25 July 2017

Our Ref: X00068  
File No: 2017/370519-01

**RE: Notice of Exhibition – Sydney Metro City and Southwest (Chatswood to Sydenham) Modification 3 – Martin Place (SSI 7400 MOD 3)**

**Figure 3 – Sydney Metro Martin Place Station – proposed modification layout**  
(Source: Martin Place Station Modification Submissions Report, Transport for NSW, 2017)

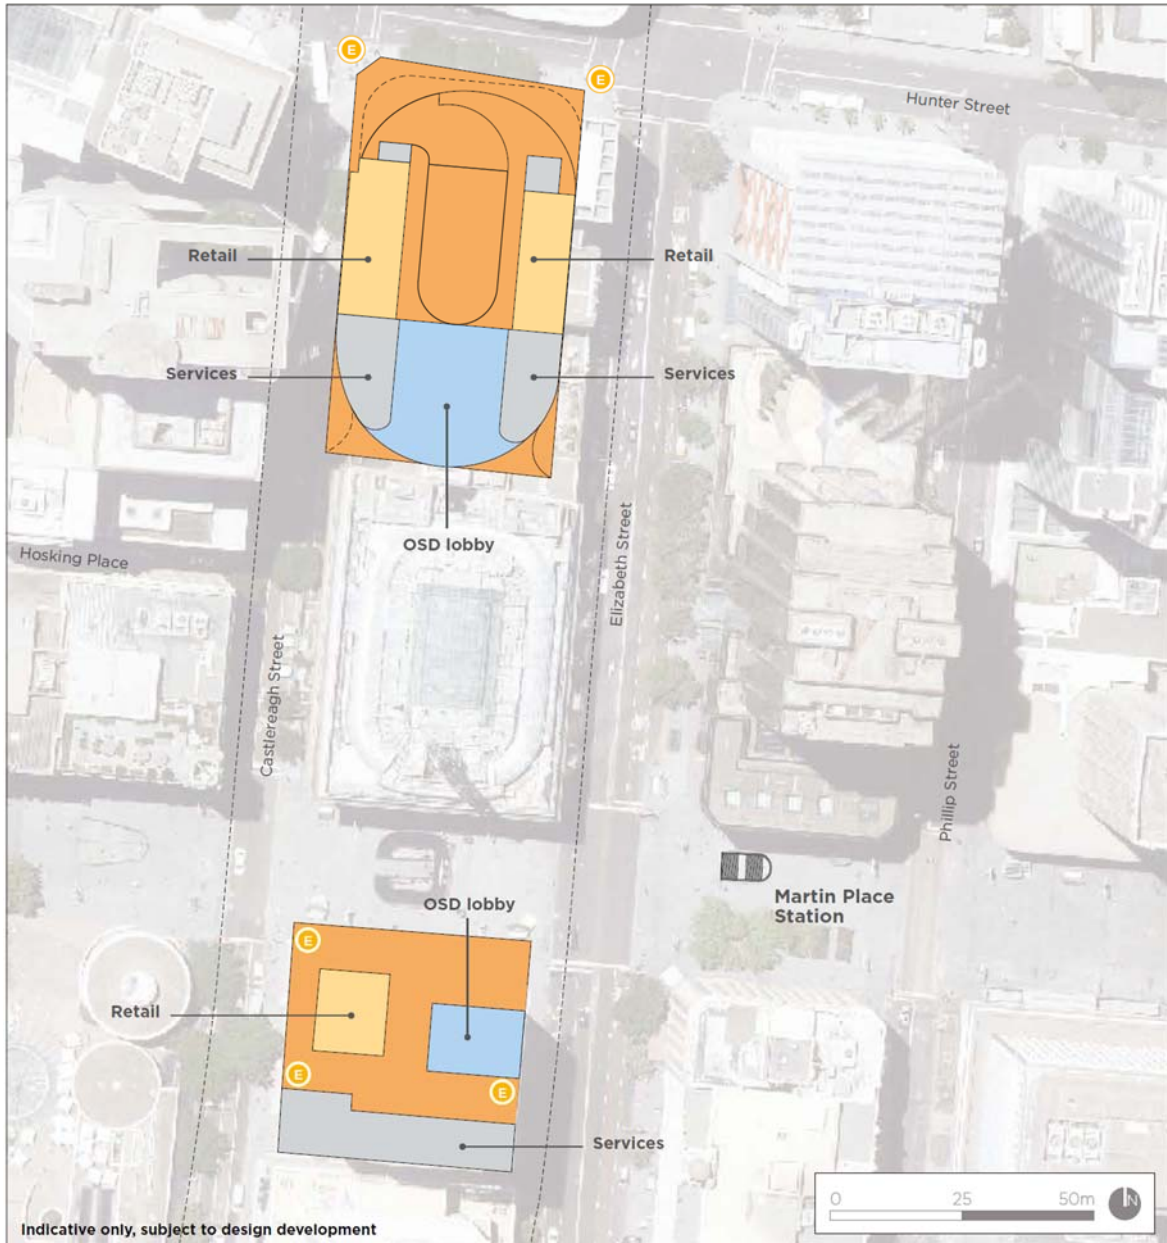
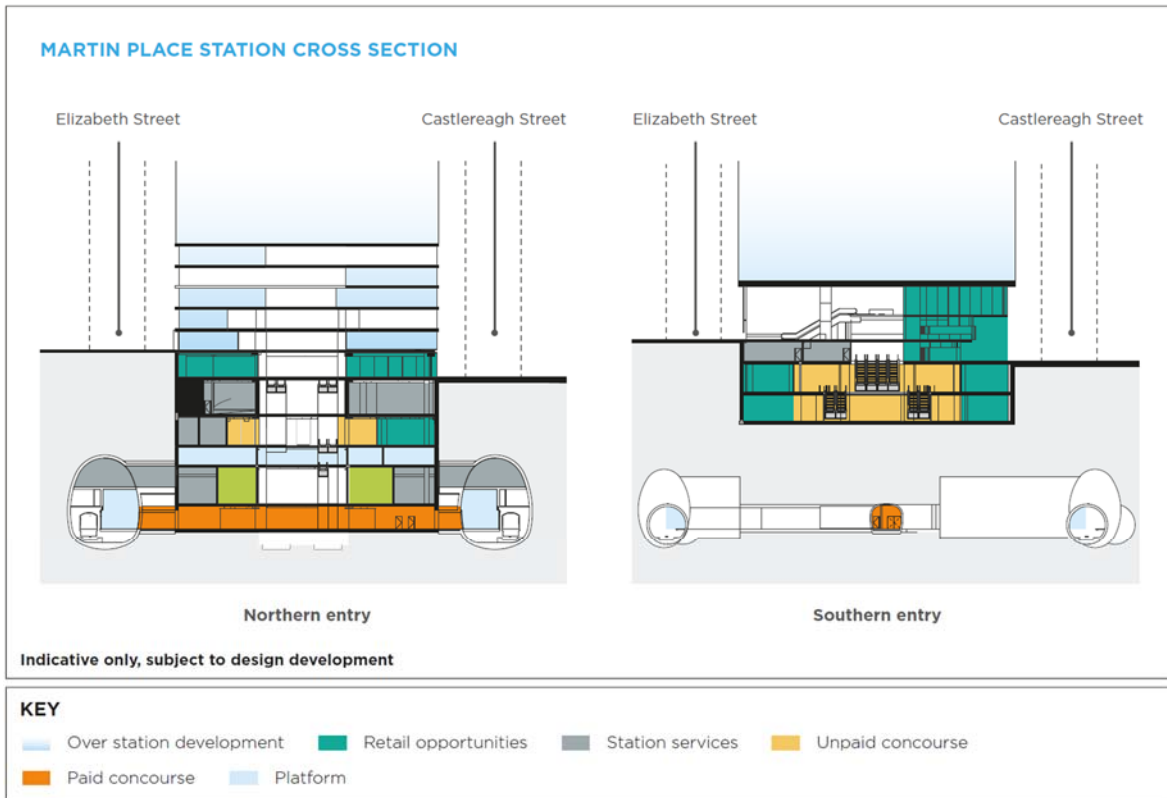
It is also noted that the plans for the proposed station entries are inconsistent with the cross-sections provided and are misleading. The plans show that the whole site area will be occupied by a pedestrian plaza/station lobby, with some service and operational area. This is not the case because, as shown by the cross-sections, it is clearly intended that some of this space will be occupied by Over Station Development (OSD) entries and retail, particularly in the northern station.

Due to the inaccuracy of the plans, it is not possible to determine if the station area is larger than the approved works, but it appears that it is not.

Figure 4-1 Indicative station entry layout

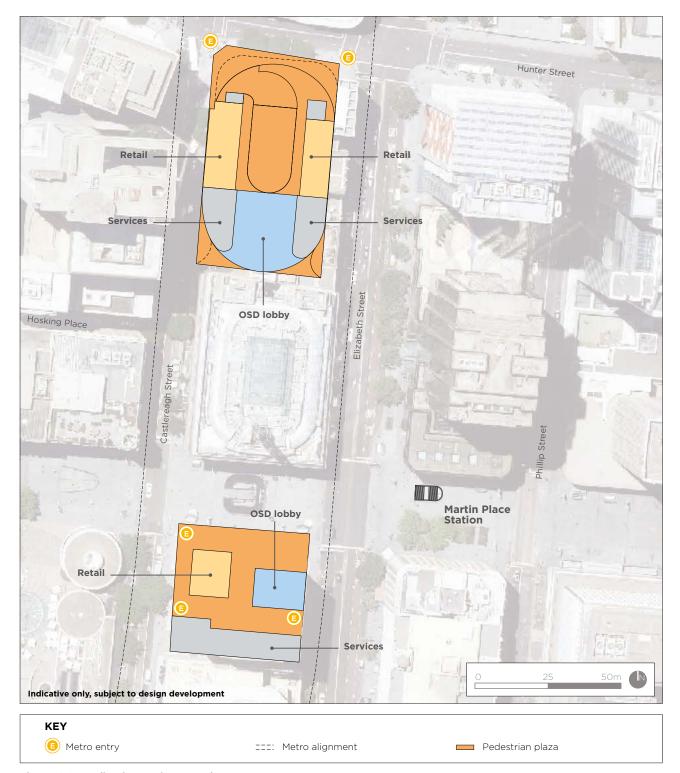
- The frontages to Castlereagh and Elizabeth Streets should be sleeved with retail to activate the street, services should be located behind.
- The curved openings between 52 Martin Place and the Station entry are not supported. These should be square to the street in the mid-block area to maintain definition of the street edge and continuation of the urban character.
